Your Ref	SSD-10354-Mod 3
Our Ref	NCA/4/2019
Contact	Paul Sartor
Telephone	9806 5740
Email	psartor@cityofparramatta.nsw.gov.au

1 JUNE 2023

**COUNCIL SUBMISSION
NOTICE OF EXHIBITION OF MODIFICATION REPORT 3 FOR THE CRICKET NSW COE –
MOD 3 (WILSON PARK, SILVERWATER ROAD)**

Ground Floor Plan

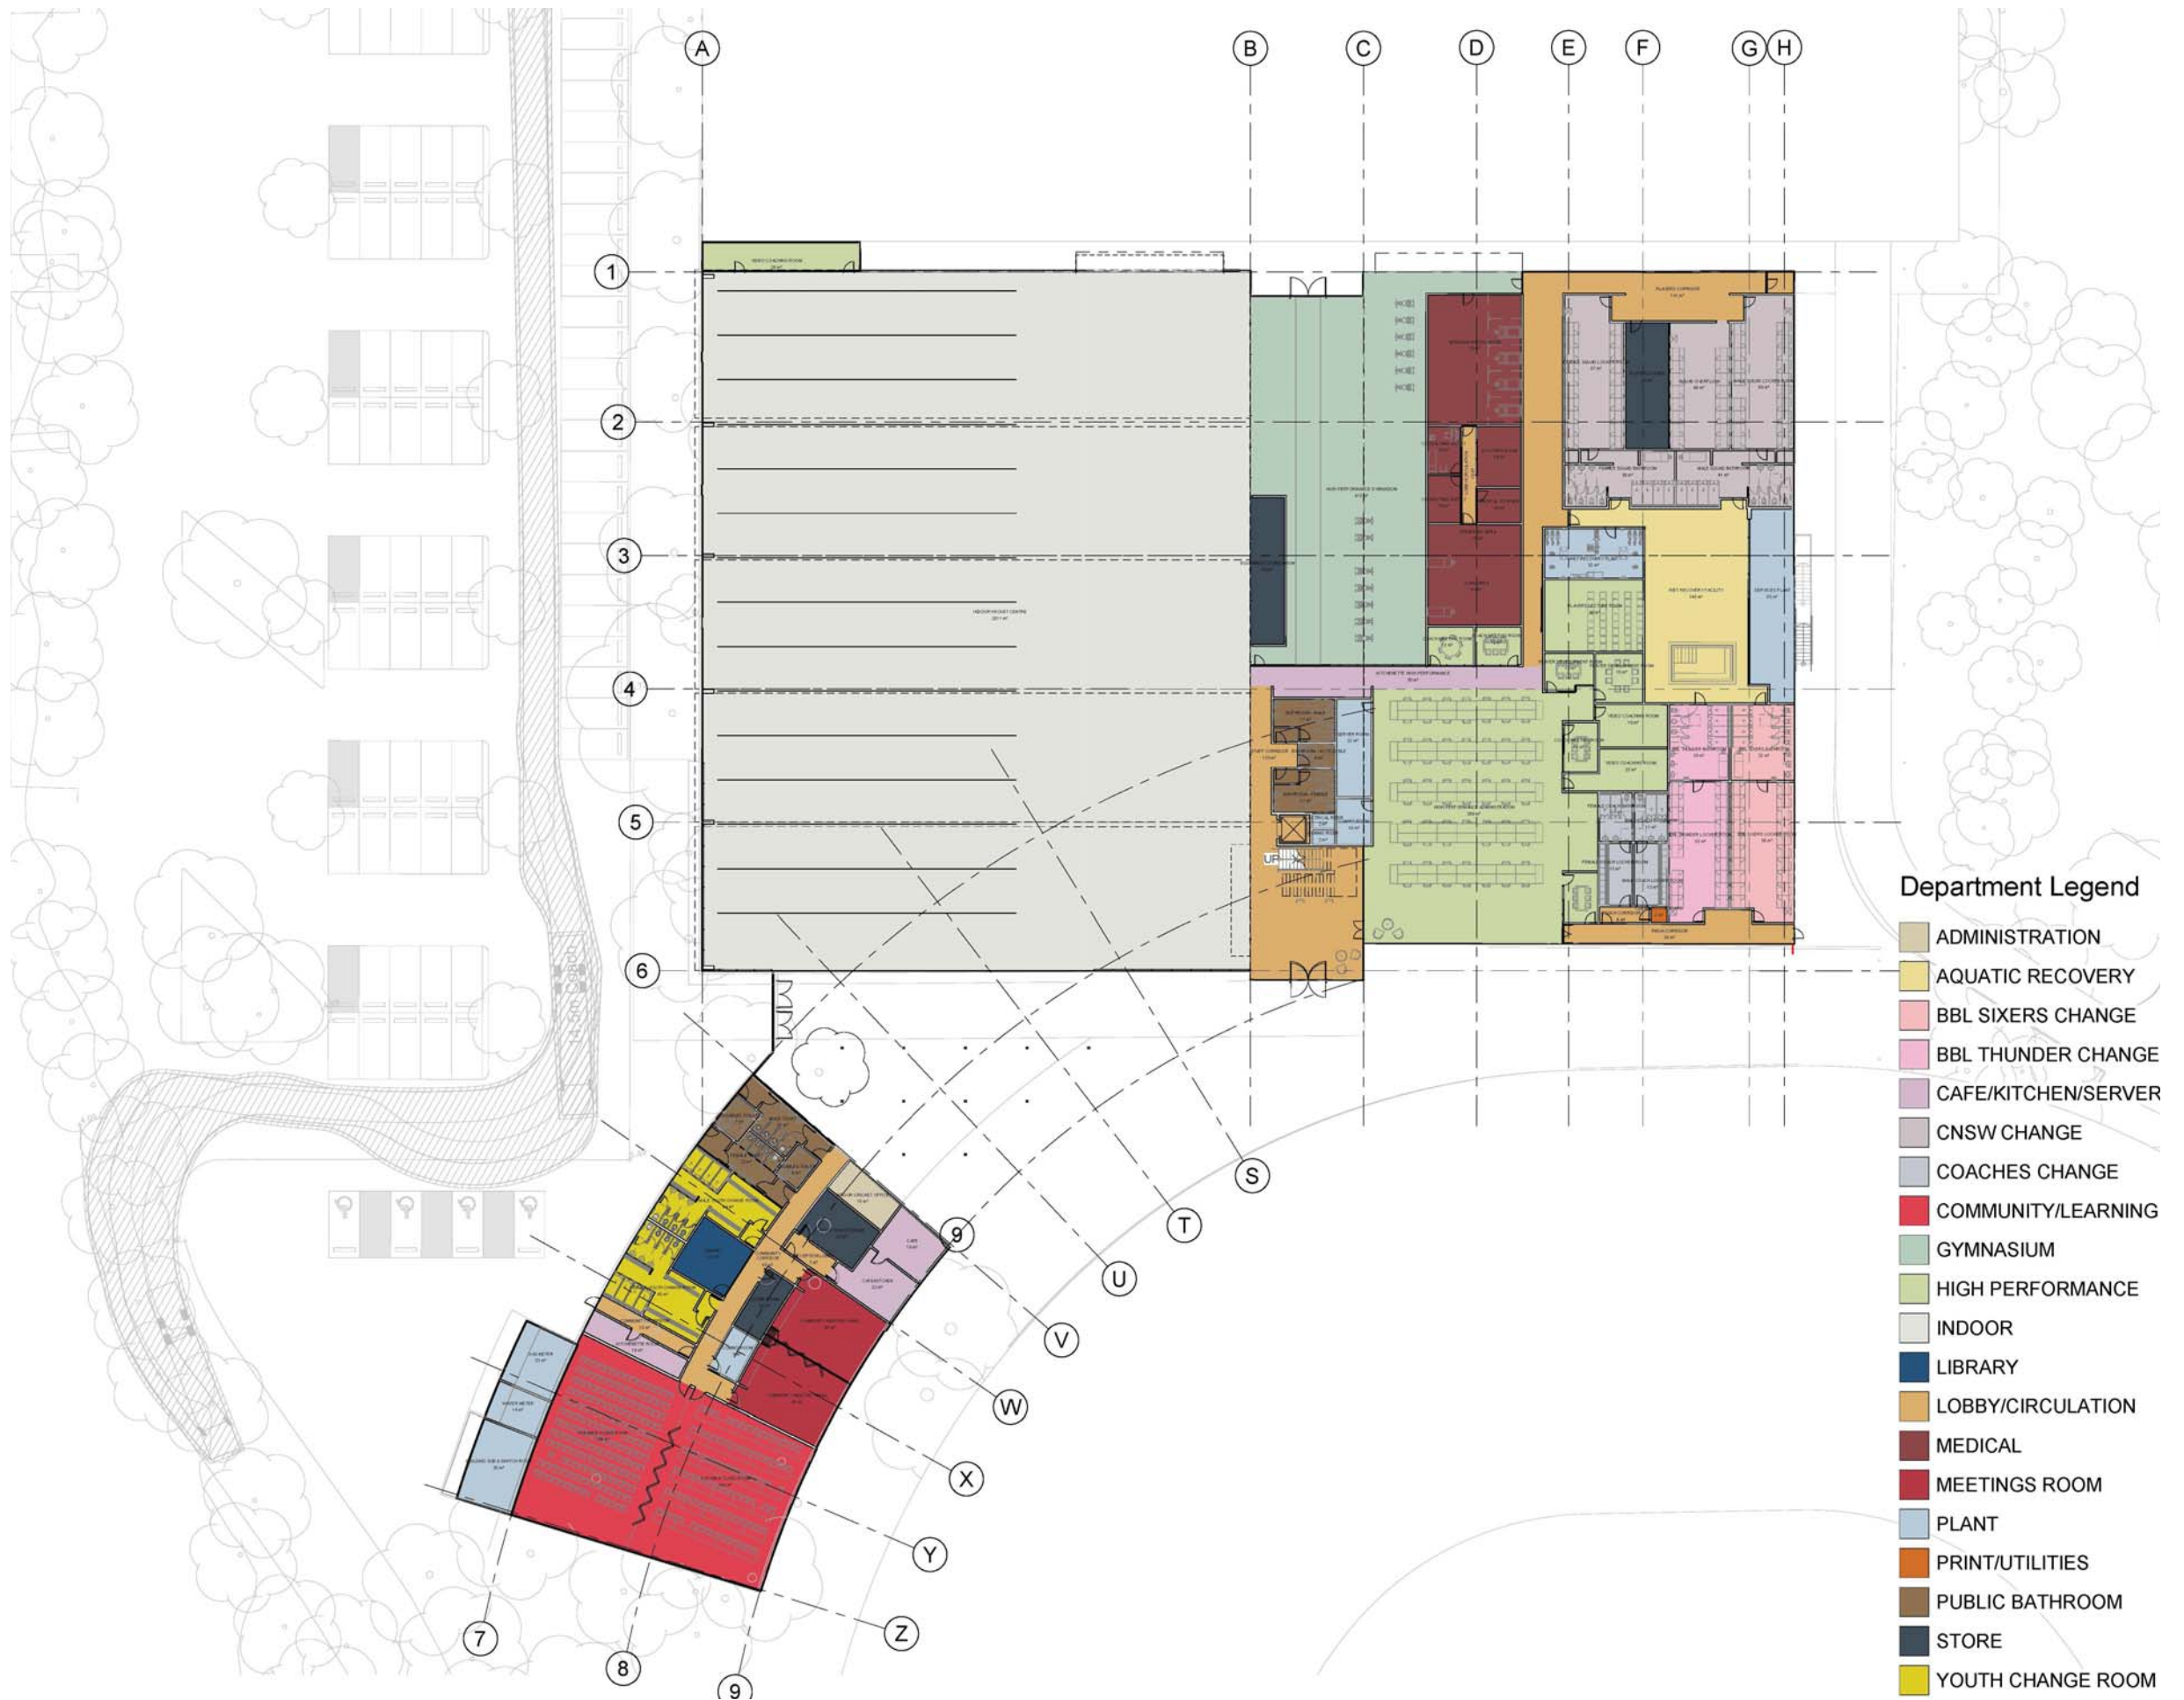
- There is no accessible sanitary facility on the ground floor area
- There is no accessible seating allocated space on the ground floor level as per BCA Table D3.9
- An additional accessible seating space is required on the 1st floor level as per BCA Table D3.9

The absence of these items put the centre at risk of action under the Disability Discrimination Act.
